Reference number: TR010032  
Document reference: TR010032/EXAM/10.24

## A122 Lower Thames Crossing (Reference Number TR010032)

### 1 Applicant's third notification to submit a request for proposed change to the application for development consent

## 10.25 Third Notification of Proposed Changes to the Planning Inspectorate

A. Works Plans Composite - Sheet 45 (M25 junction 29 and surrounding land)
 (Work Numbers: 9D, 9E, 9F, 9G, 9I, 9J, 9K, 9L, 9P, 9U, 9Z, MU85, MU87, MU88, MU89, MU90, MUT32)

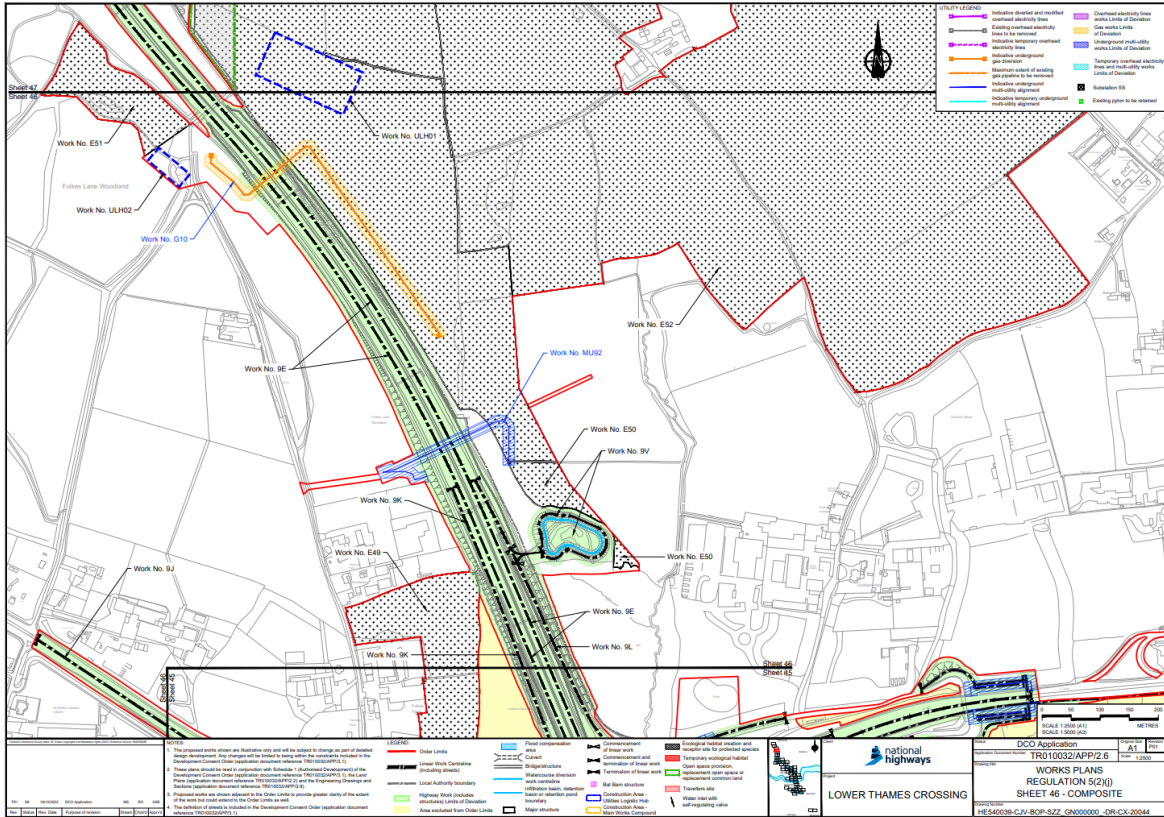
2.2.2 Proposed change EC03 seeks additional flexibility to increase the Highway Works horizontal Limits of Deviation by approximately 580 sqm to the north of the A127E WCH overbridge to avoid any conflict with the delivery of a new

- 2.2.3 The Applicant's A127E WCH bridge is as described under Work No. 9Z of Schedule 1 of the draft Development Consent Order [[REP1-042](#)] and shown on sheet 45 of 2.6 Works Plans (Volume C) Composite (Sheets 21 to 49) [[APP-020](#)]

- 2.2.5 The Applicant has, and will continue to, engage with St Modwen, the landowner and other parties throughout the detailed design of both projects, to ensure a coordinated approach to implementation is taken. To allow a reasonable amount of flexibility in the detailed design for the Applicant to accommodate the BEP bridge the Applicant seeks to increase the Limits of Deviation to the north of the A127E structure.

- 2.2.6 The land required for the proposed increase to the Limits of Deviation is already identified for permanent acquisition in the Land Plans - Volume C - (Sheets 21 to 49) [[REP1-011](#)] so there is no change to land requirements. The change would not involve any modification to the vertical limits of deviation and would not result in any new or materially different environmental effects.
